Consultee Comments for Planning Application 21/02032/FUL

Application Number: 21/02032/FUL

Address: Weeping Ash Ardleigh Road Great Bromley Colchester Essex CO7 7TL

Proposal: Provision of new 5 Bed, 9 Person detached house with integral garage and improvements to existing vehicular access.

Block Plan Plot 2 Scale 1:200

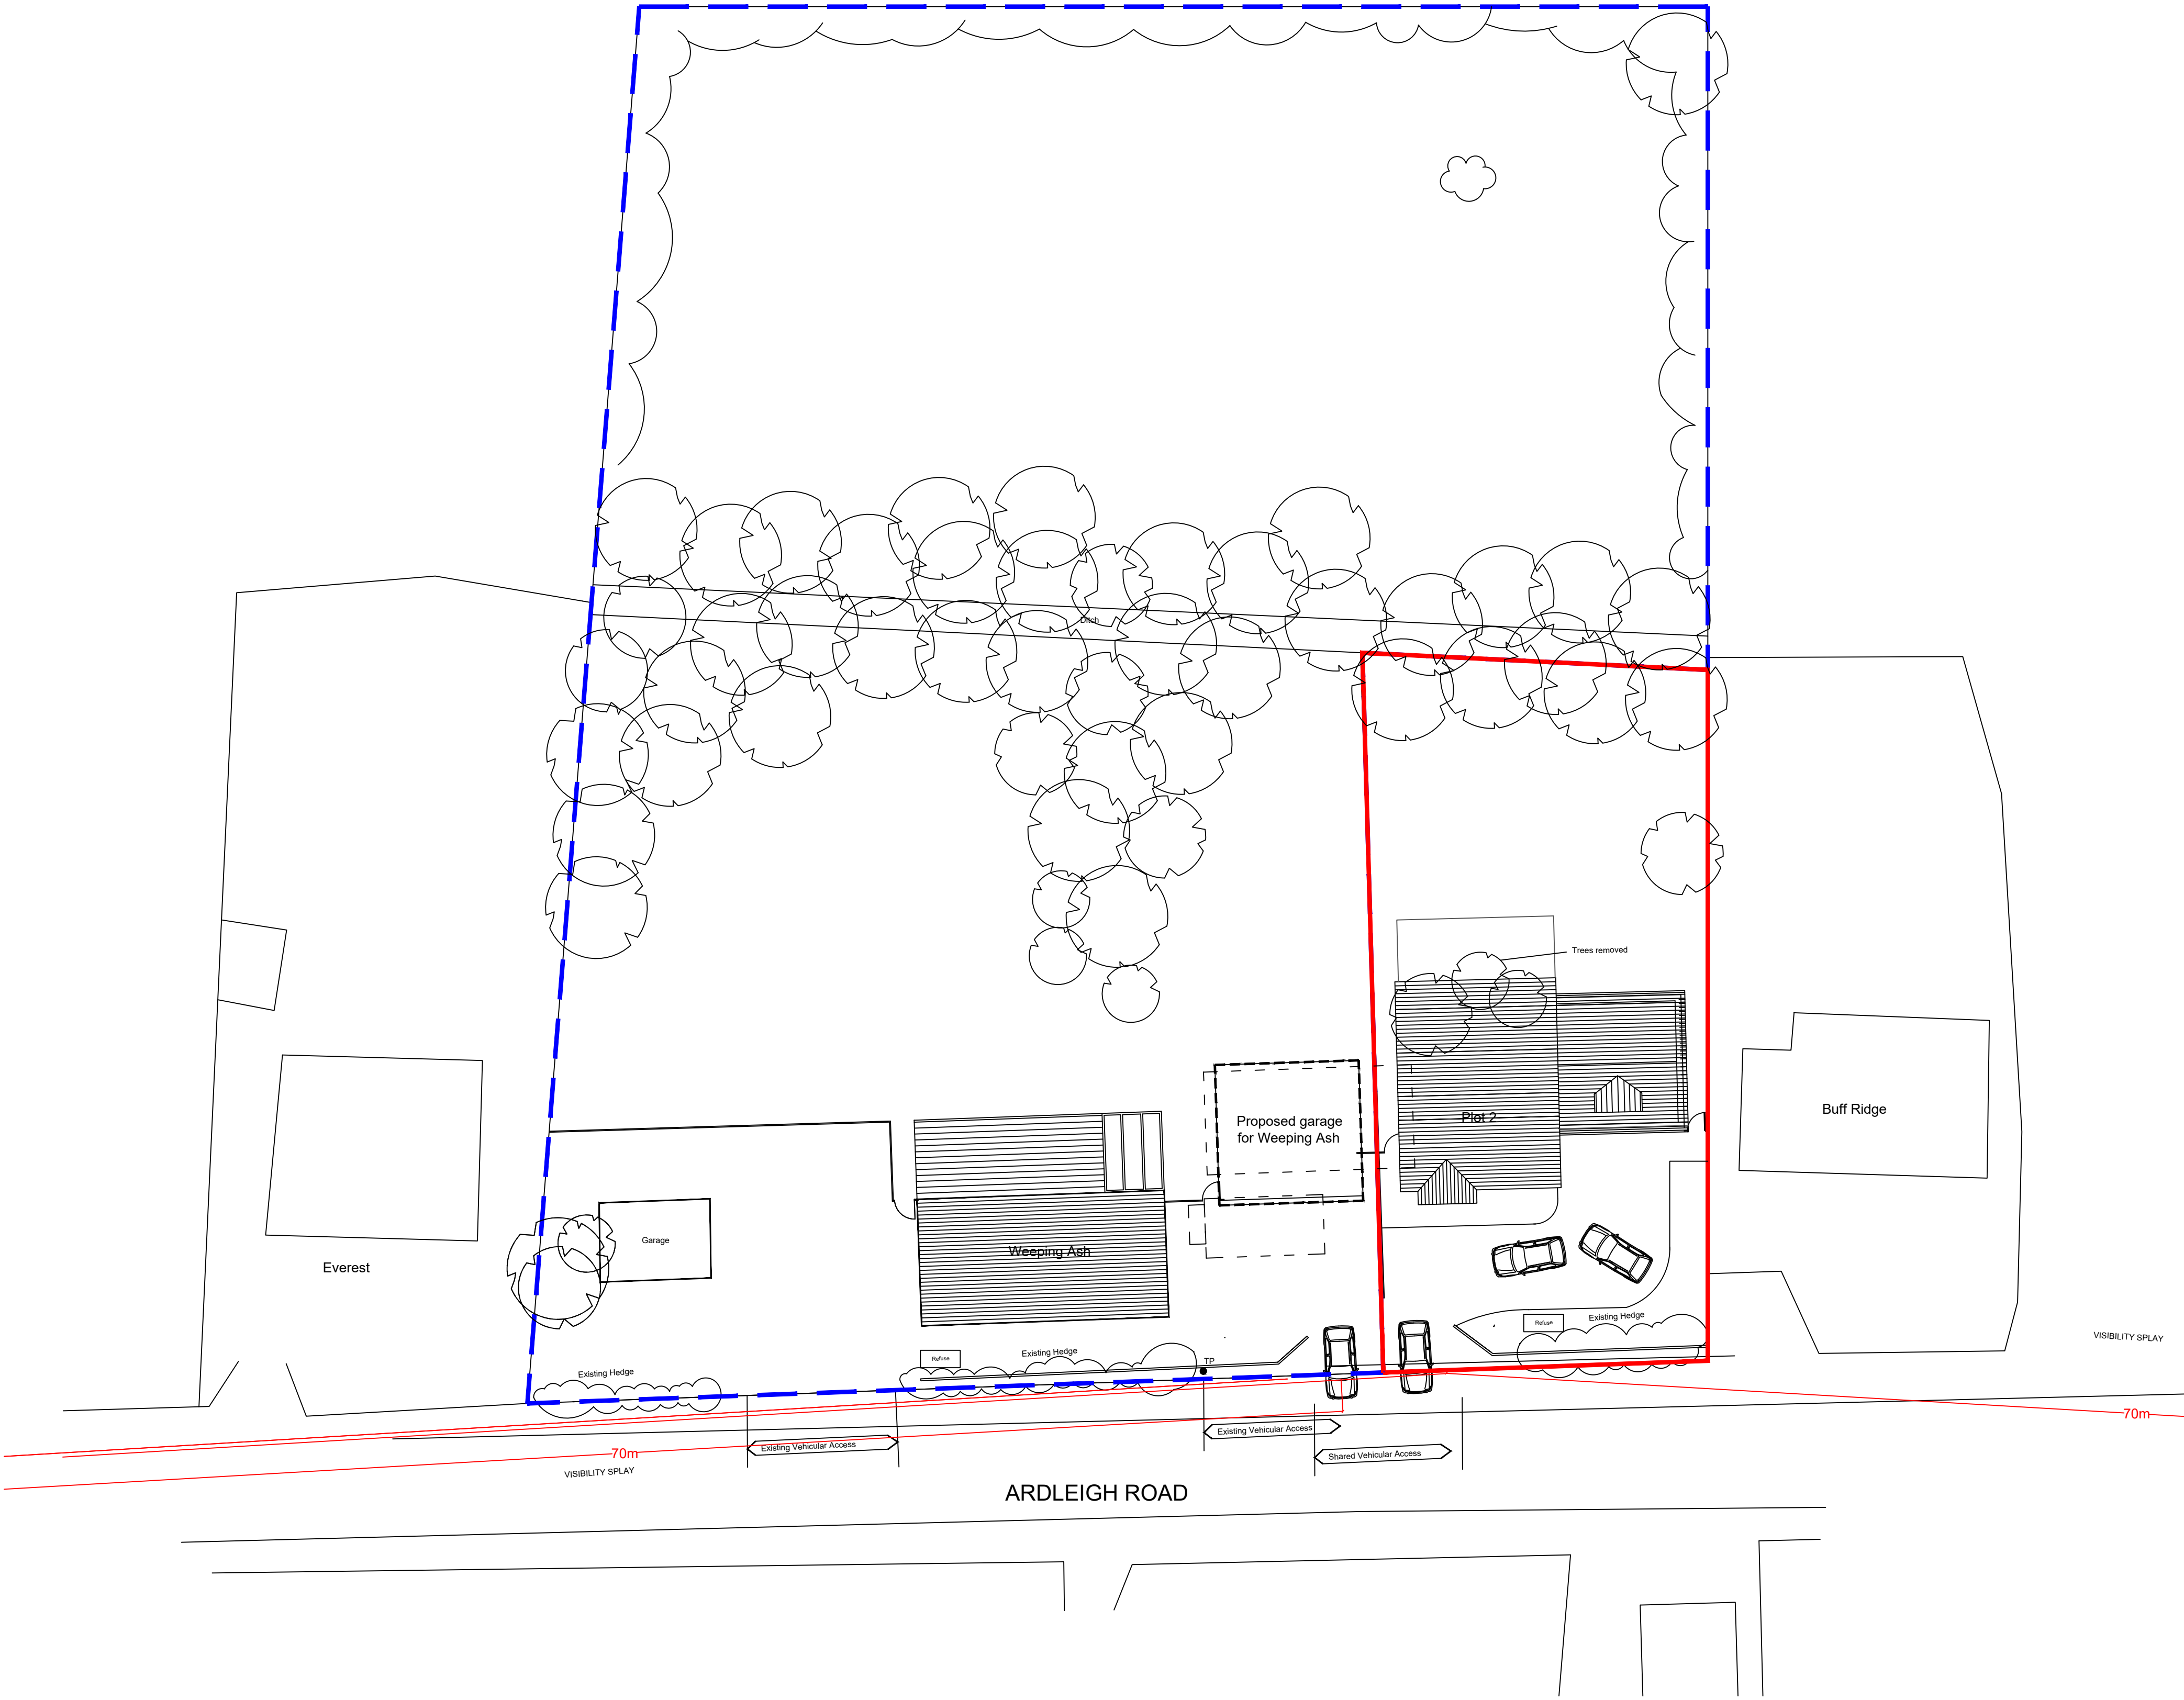
From an examination of the proposed site layout it appears that it may be possible to retain the Tortured Willow; if this is not possible then the amenity value of the existing tree could be relatively easily replicated by the planting of a replacement tree.

Should planning permission be likely to be granted then details of soft landscaping for the front garden should be secured by a planning condition.

The purpose of the planting should be to aim to replicate the contribution that the existing trees and hedge makes to the appearance of the public realm and to soften screen and enhance the

appearance of the development.
